**RE: 7200 Bluewater
Grading and Drainage Plan
Engineer's Stamp Date: 10/08/18
Hydrology File: K10D060**

Based upon the information provided in your submittal received 10/11/2018, the Grading Plan is **not** approved for Building Permit and Site Plan for Building Permit. The following comments need to be addressed for approval of the above referenced project:

DRAWING NAME
WATER/SEWER
PLAN

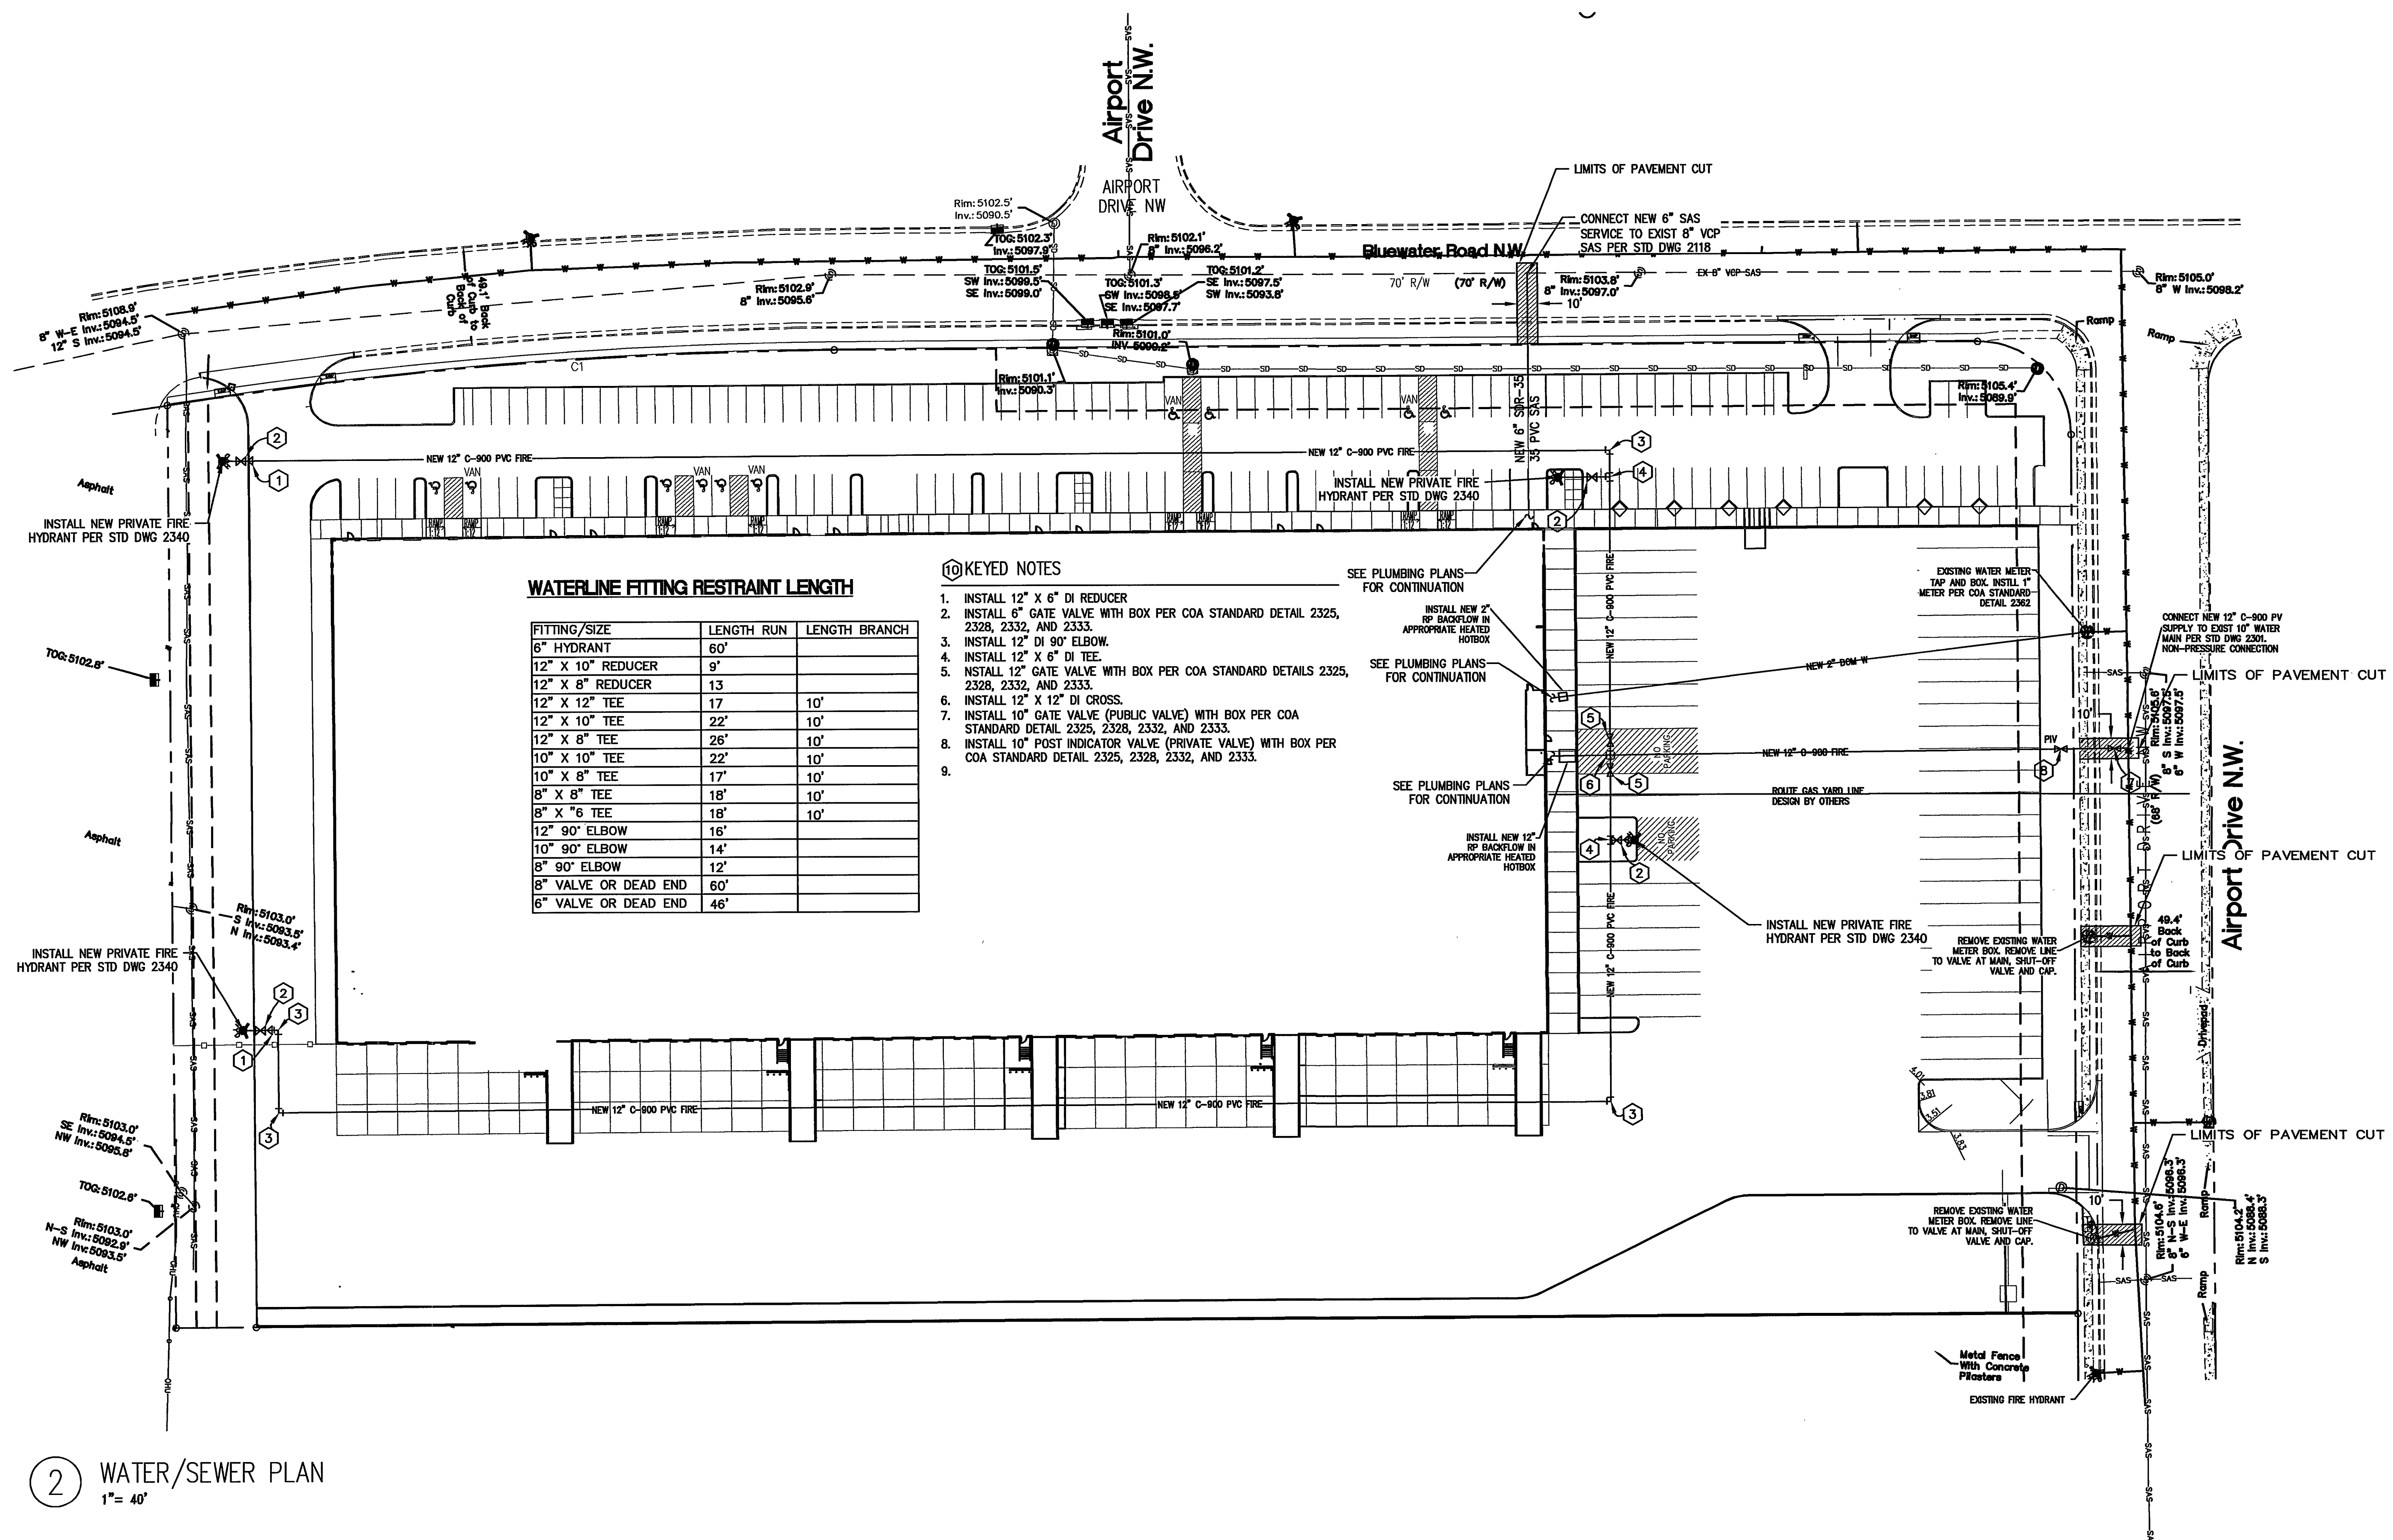
7. Sheet C-2. Please provide the weir calculations for the curb cuts.
8. Sheet C-2. Under Developed Conditions, please insure that the statement includes that the site (10.33 ac) has an allowable discharge of 1.136 cfs and the proposed discharge is 1.08 cfs.

GRADING PLAN

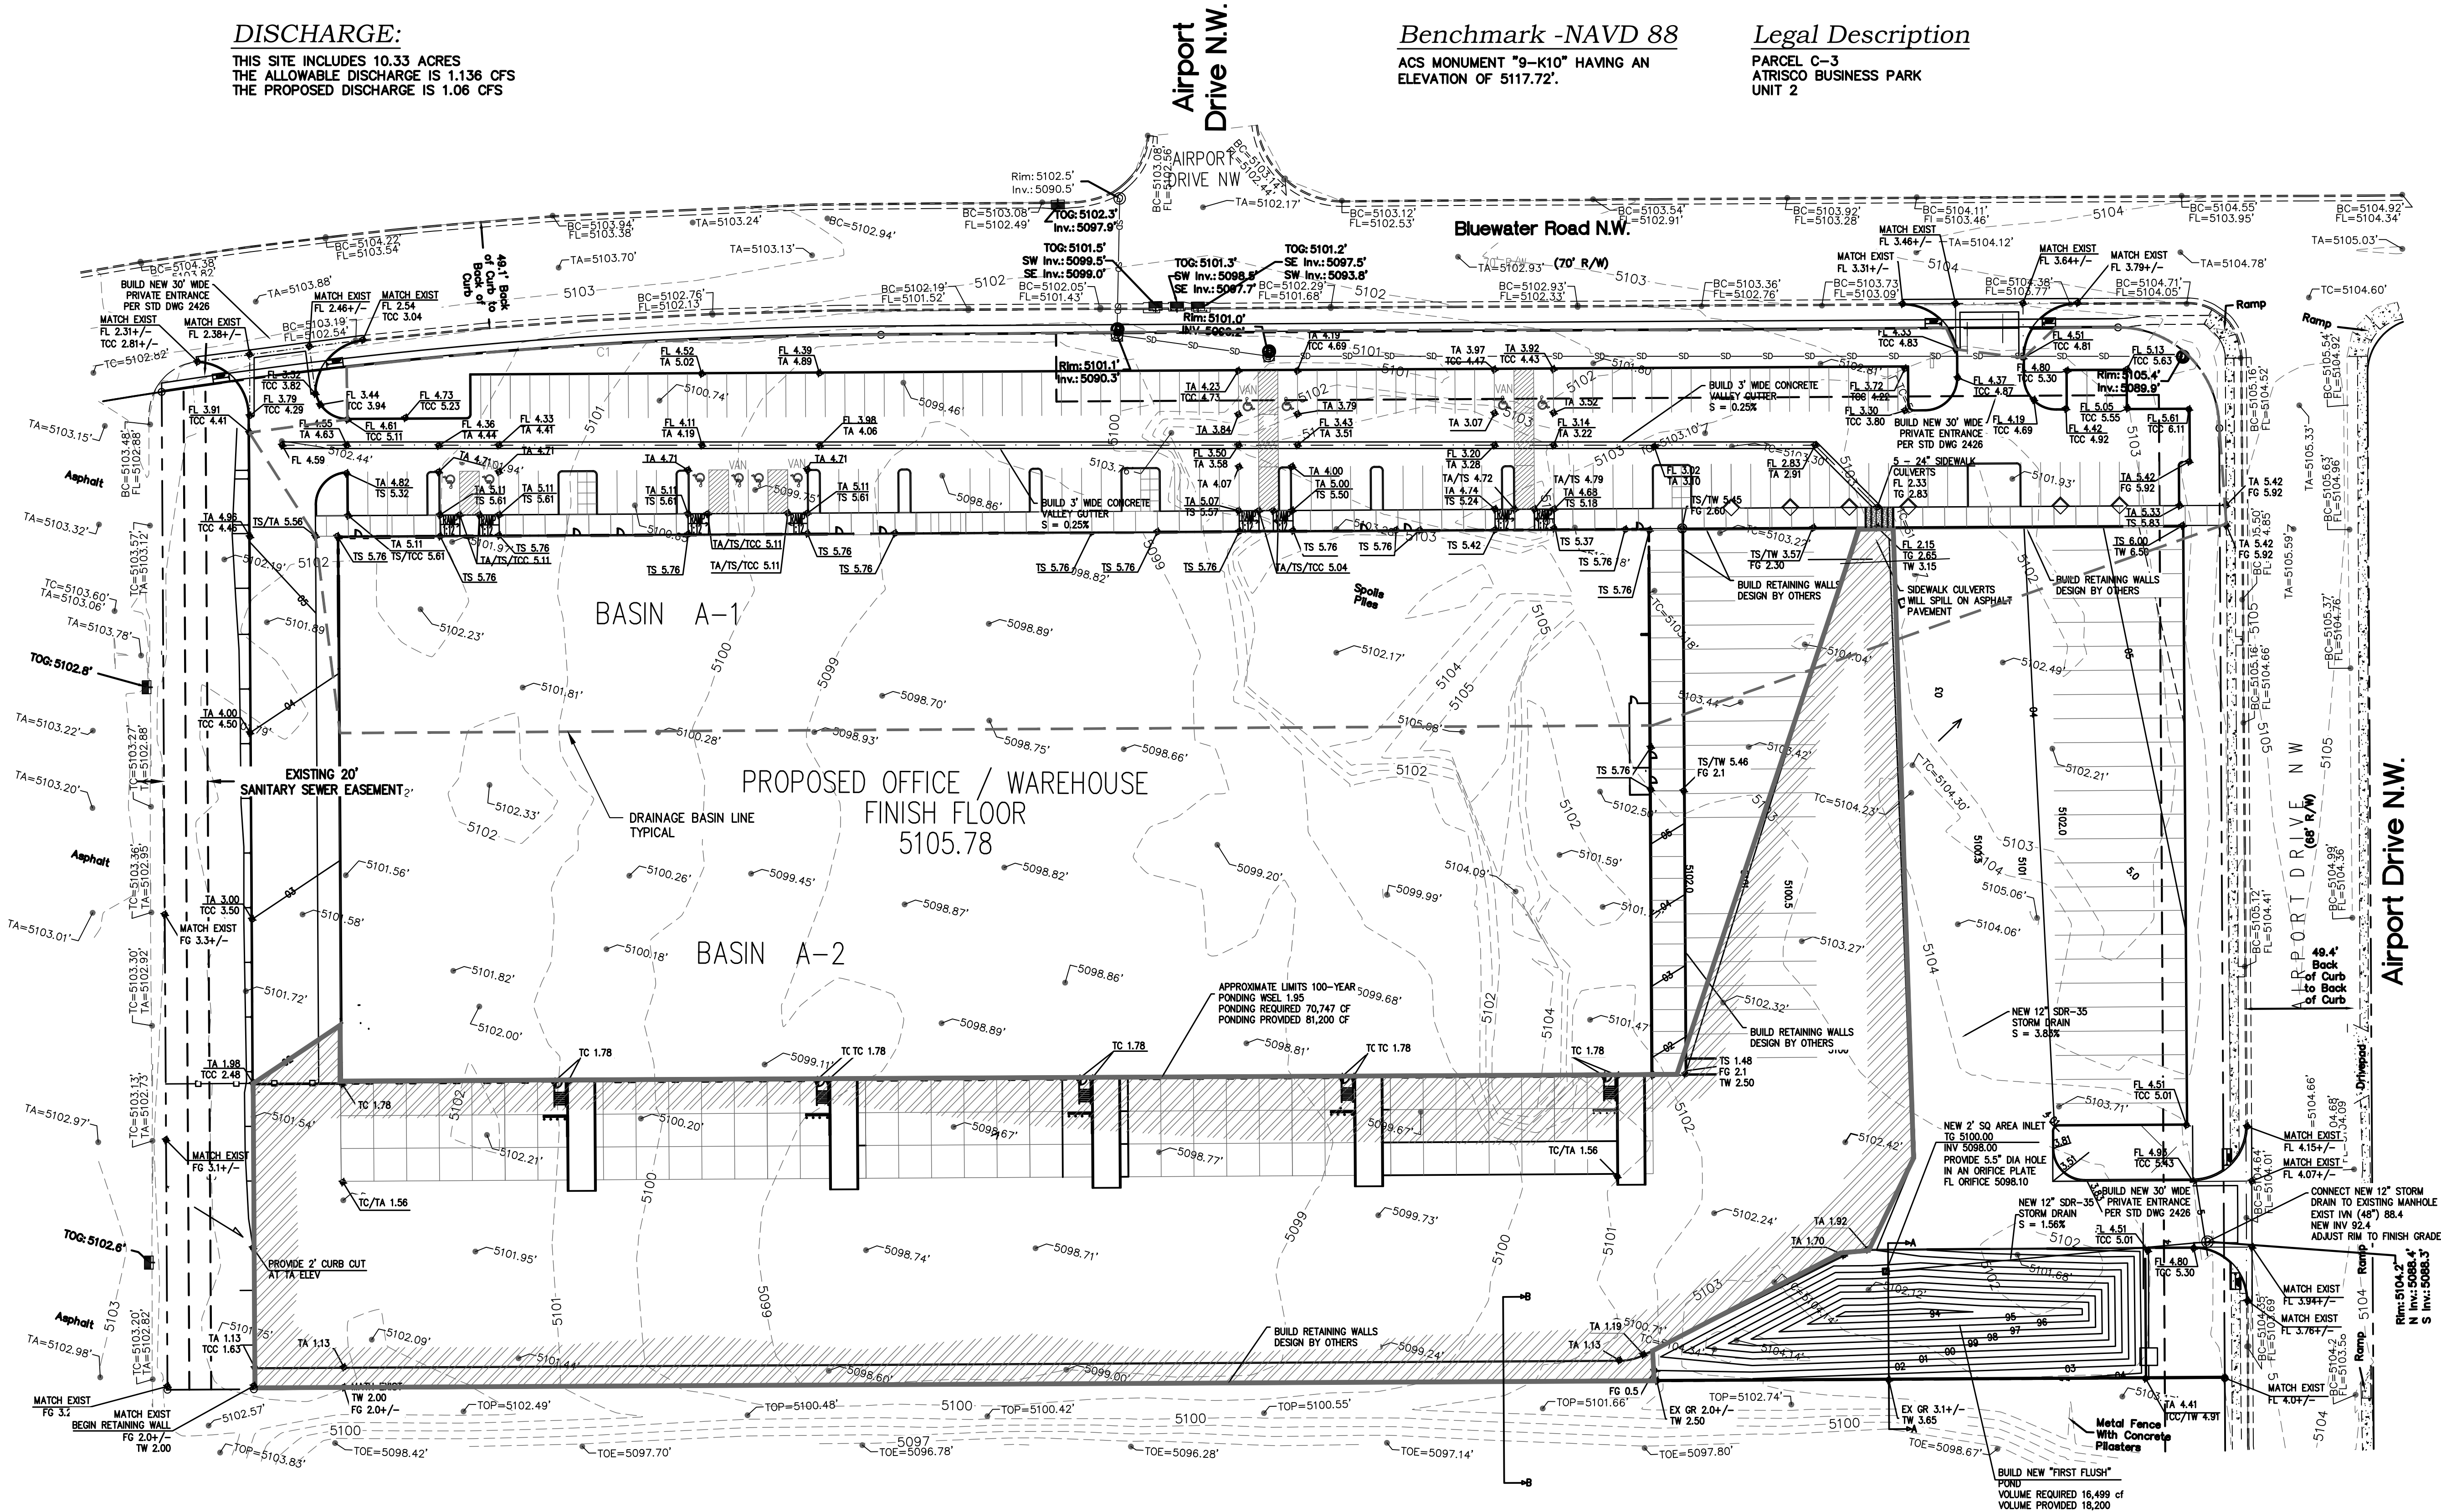
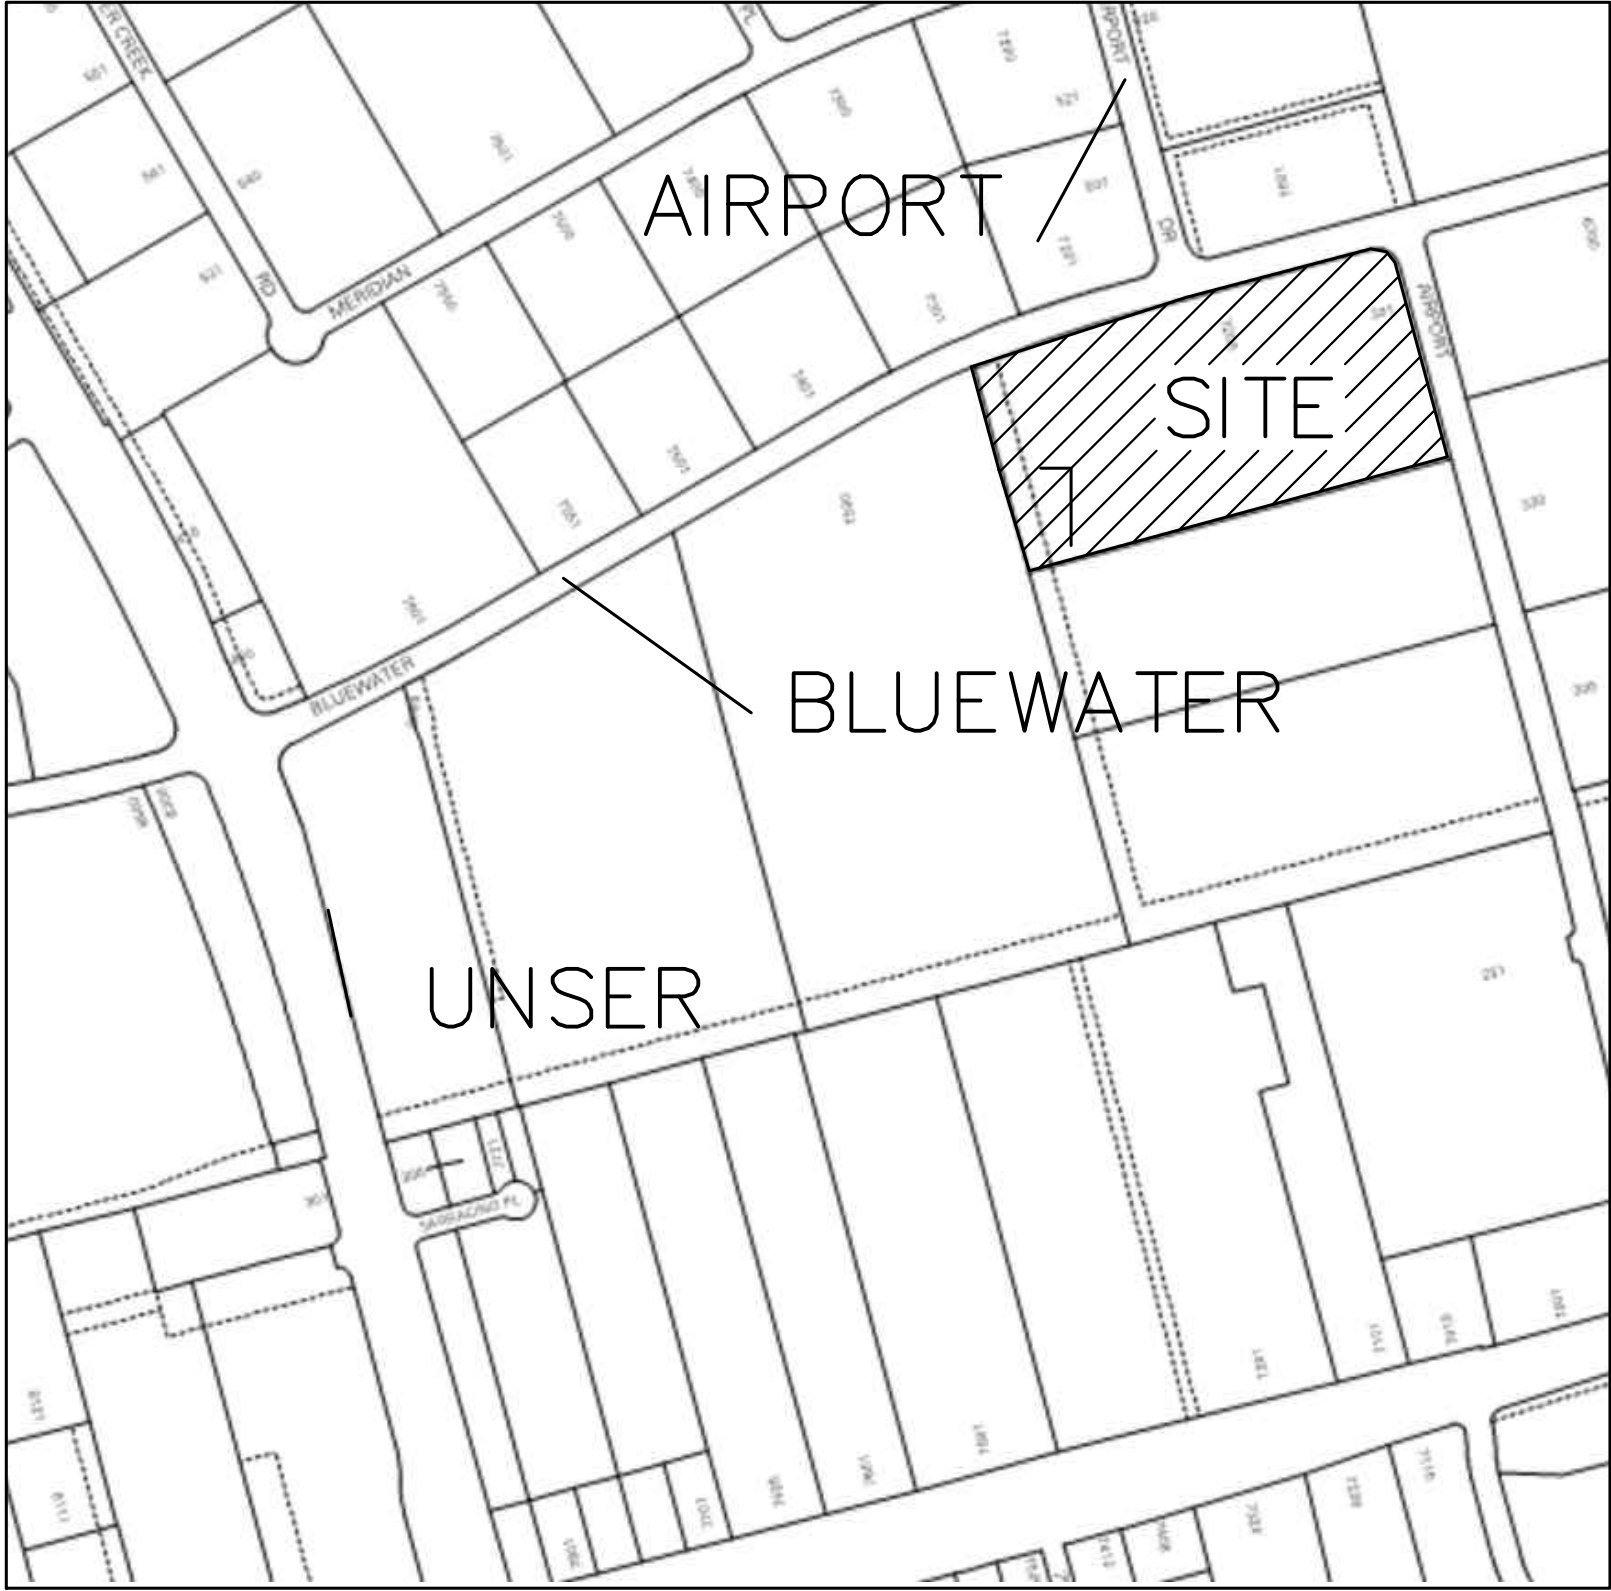
1. Sheet C-1. Please provide the benchmark information for the survey contour information provided.
2. Sheet C-1. Please provide the legal description of the property.

3. Sheet C-1. Please call out the Existing 20' Public Sanitary Sewer Easement along the Northwestern property line.
4. Sheet C-1. The proposed swale can't be placed within the Existing 20' Public Sanitary Sewer Easement. You can ask for a waiver from Albuquerque Bernalillo County Water Utility Authority. If they grant a waiver, then the proposed swale can stay.

5. Sheet C-1. Please add the note of the 100-yr water surface WSEL and the volume provided in Pond 2.
6. Sheet C-1. The First Flush (storm water quality) ponds are typically placed within the landscape area. I noticed that the ponds were located within the asphalt areas. This is not acceptable unless you install a water quality manhole or inlet prior to discharge into the existing storm drain system. Also this can be done with an underground system, which can also handle the detention requirement for the site as well. Another idea is to request a variance of the first flush volume requirement, provide an explanation for this variance, and then pay the Fee in Lieu payment Amount which will be the required volume x \$8/CF. This is all your decision which works best for this project.
